# GOVERNMENT ARCHITECT NEW SOUTH WALES

Pitt Street South Over Station Development – Design Excellence

Sydney Metro Design  
Review Panel  
Letter of Design Excellence  
Pitt Street South Over  
Station Development

4.1 level 06 - plan

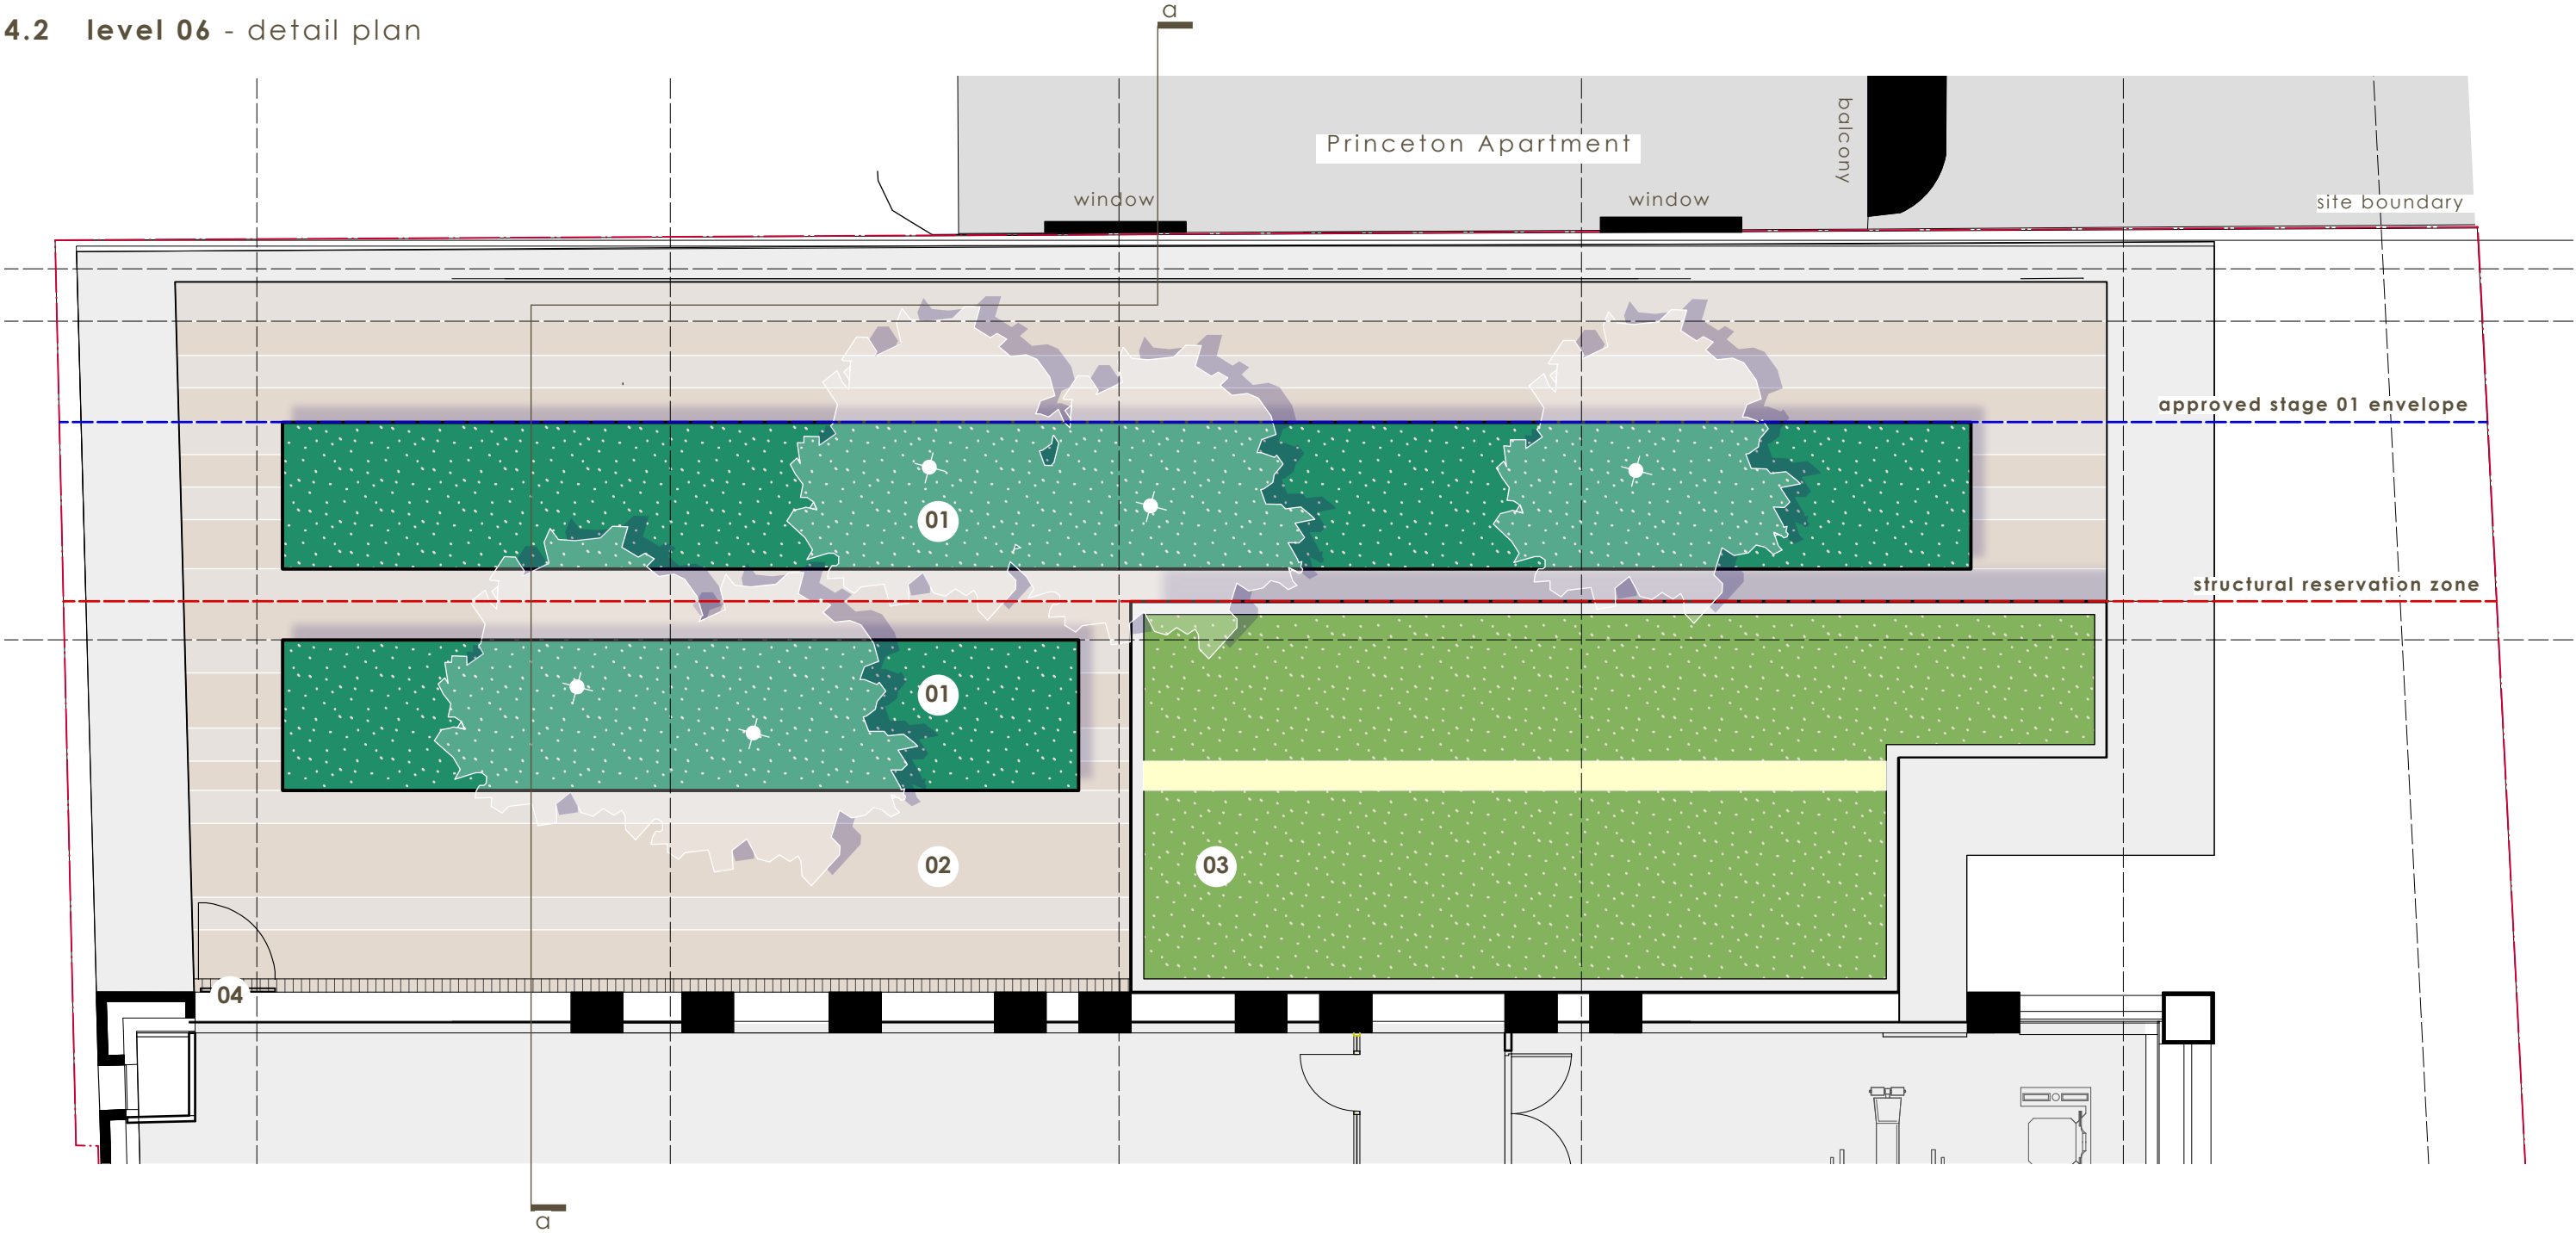
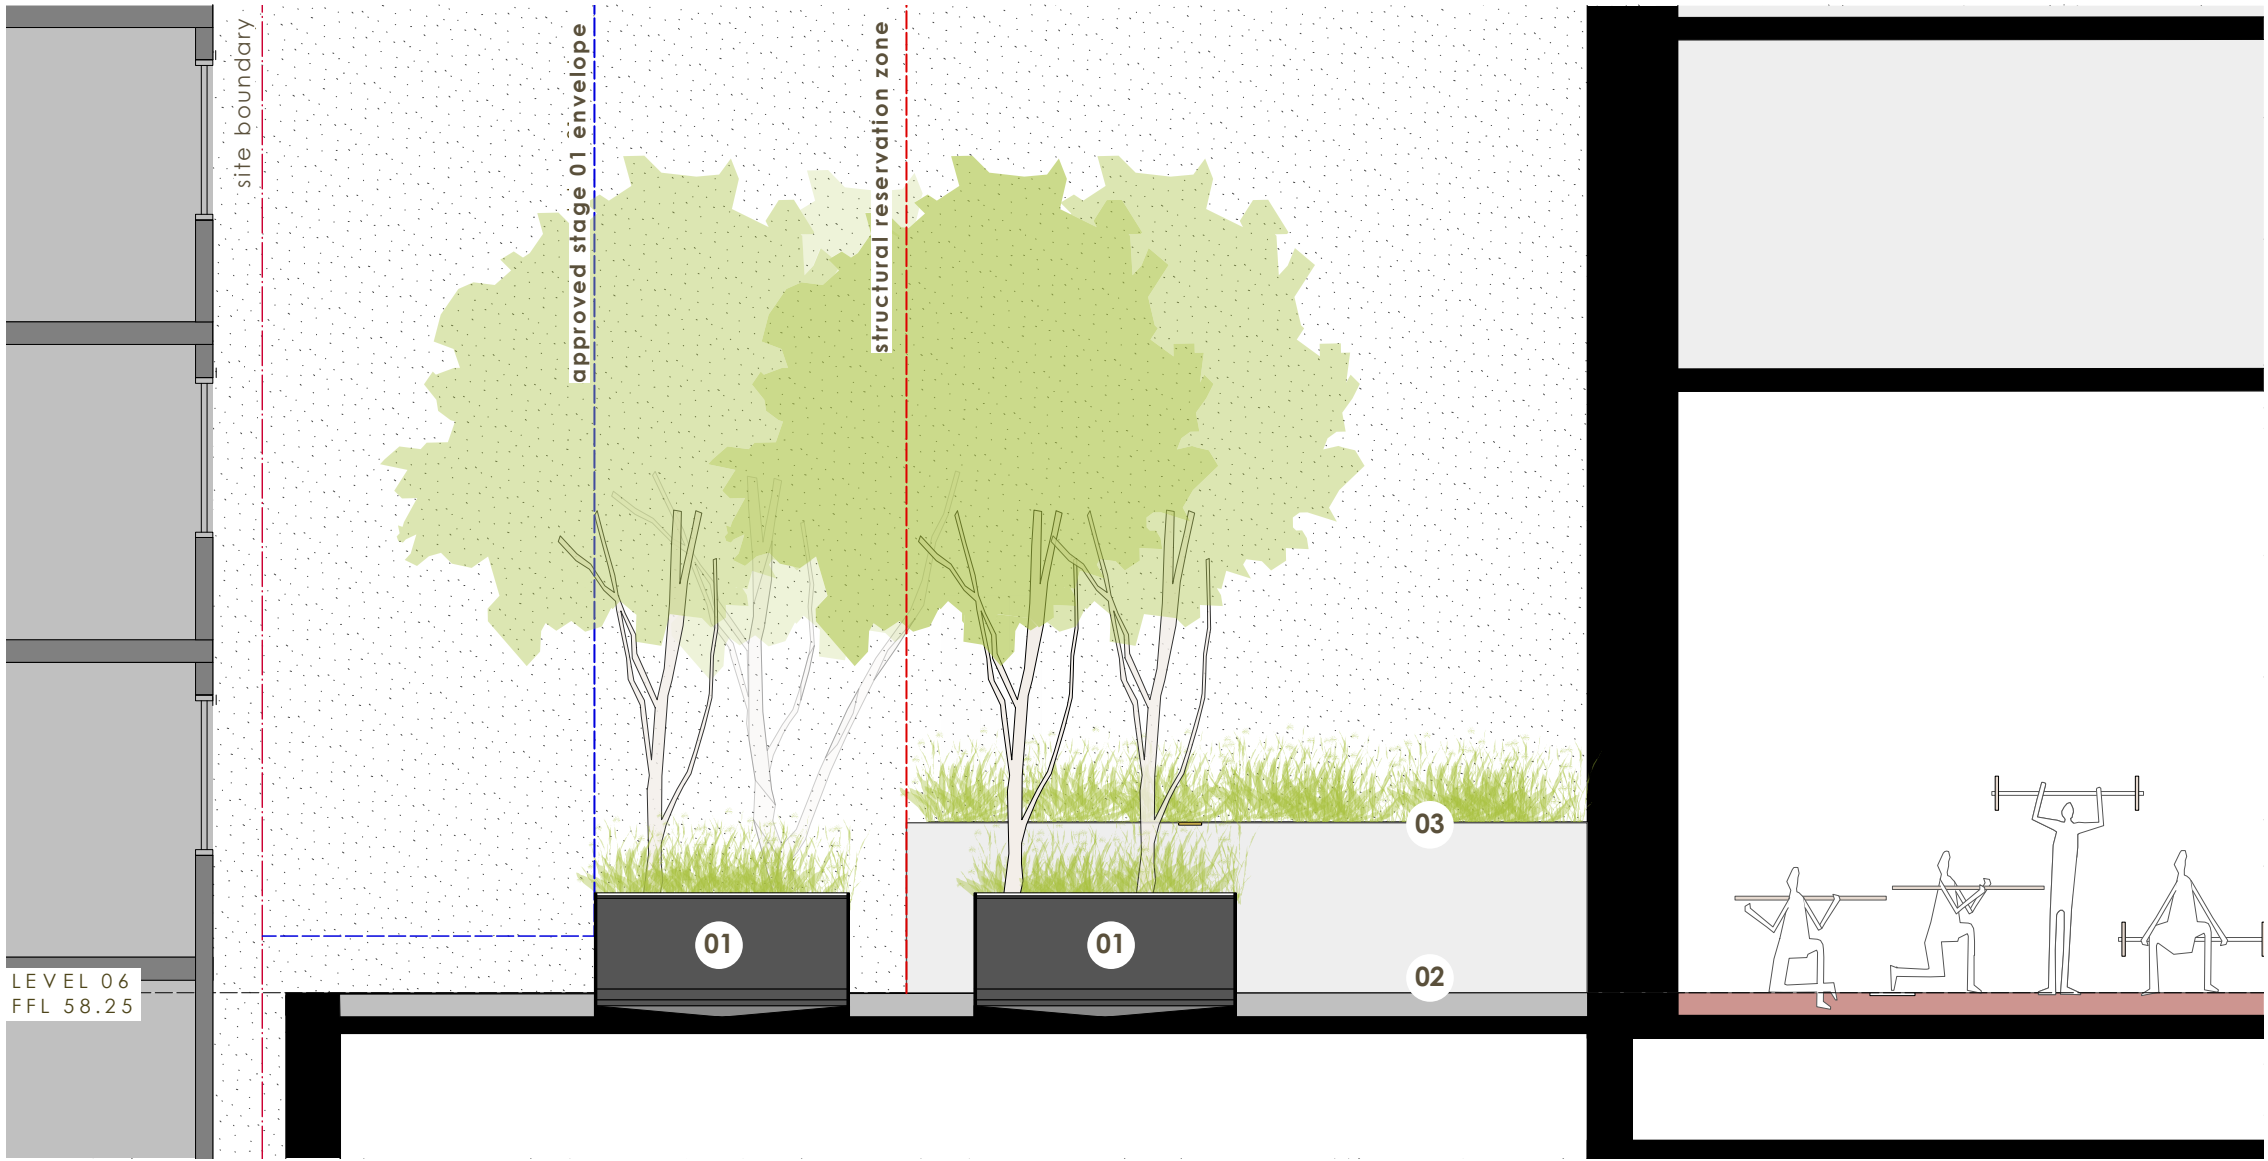
- The Panel supports the Level 6 terrace use as landscape only, and encourages the maximisation of soft landscaping through reducing extent of proposed paved area. [Redacted]
